**App no: 22.0067**

**Address: Sudell House, 75 Whalley Road, Wilpshire**

**Proposal: Removal of the existing garage and conservatory and erection of a proposed single storey extension, entrance canopy and annex.**

PROPOSED SITE PLAN  
Scale 1:200

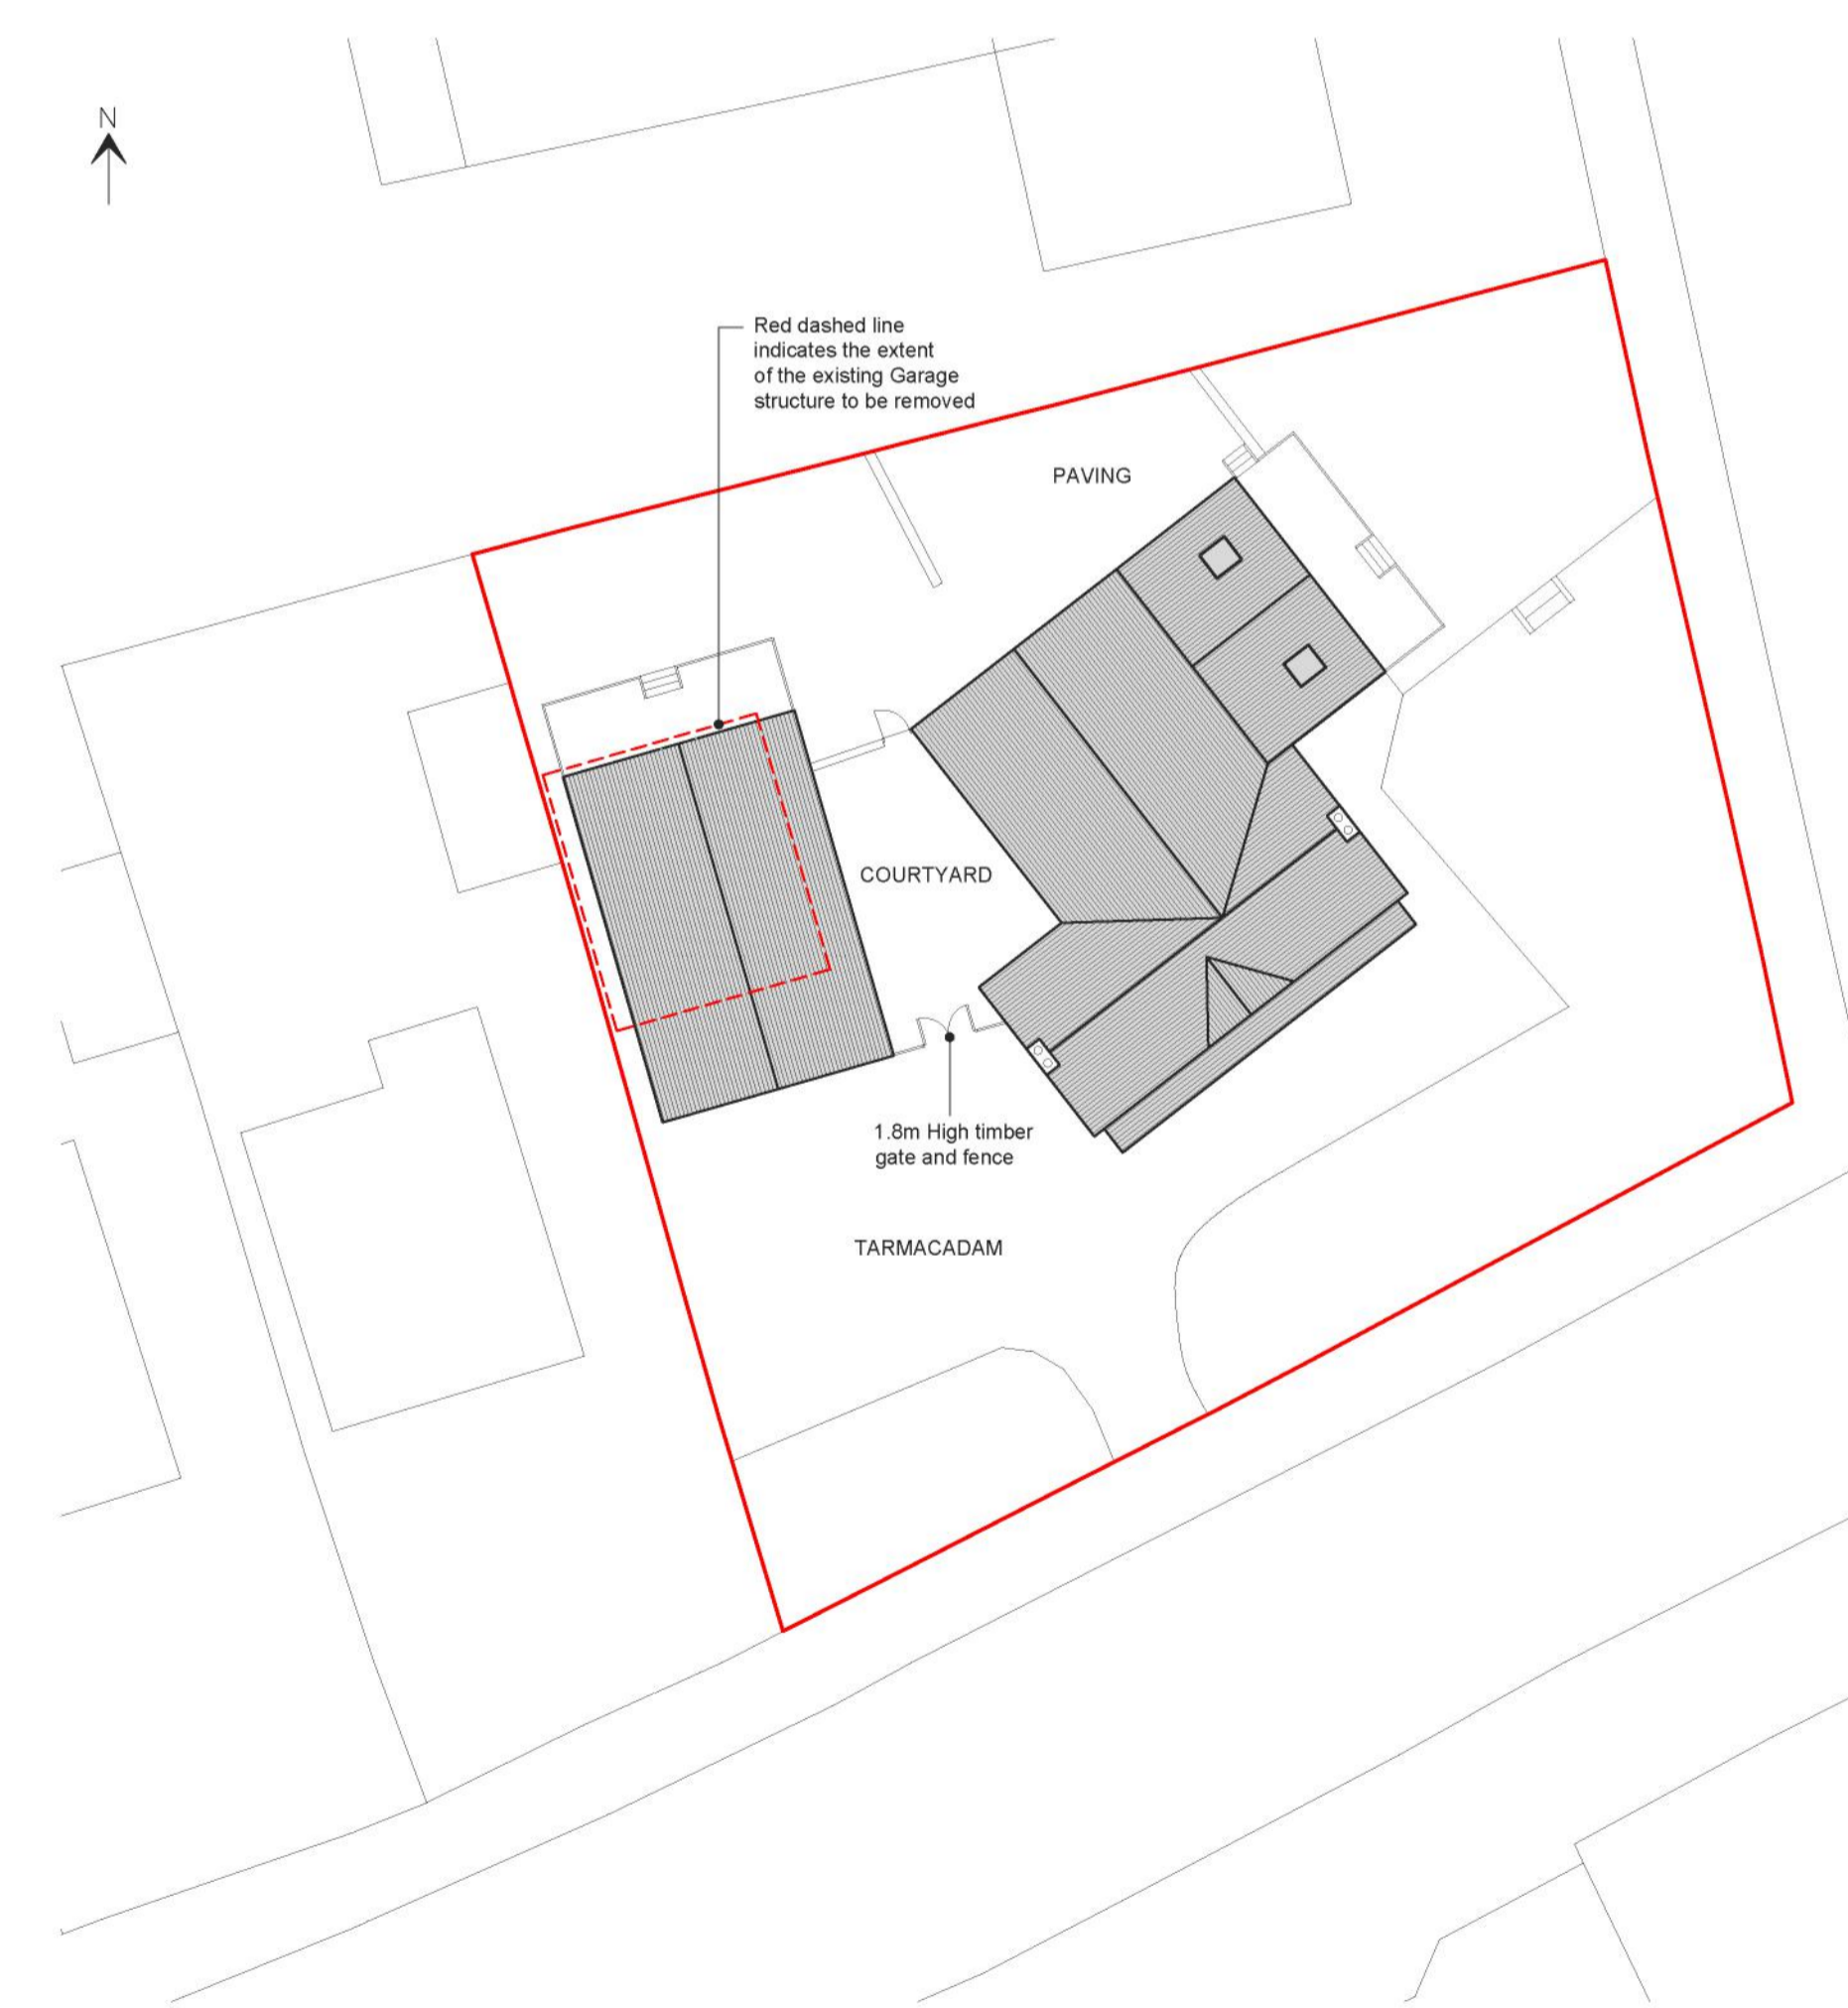
There is sufficient space on the remaining driveway hardstanding to accommodate 3 spaces for the main dwelling and a further space for the annex, with vehicles entering and leaving in forward gear. The existing access on Whalley Road will remain the same.

Due to the loss of the garage, a replacement secure cycle store should be provided at the dwelling to support sustainable travel.

1. Prior to the first use of the development hereby permitted a secure, cycle store shall be provided.
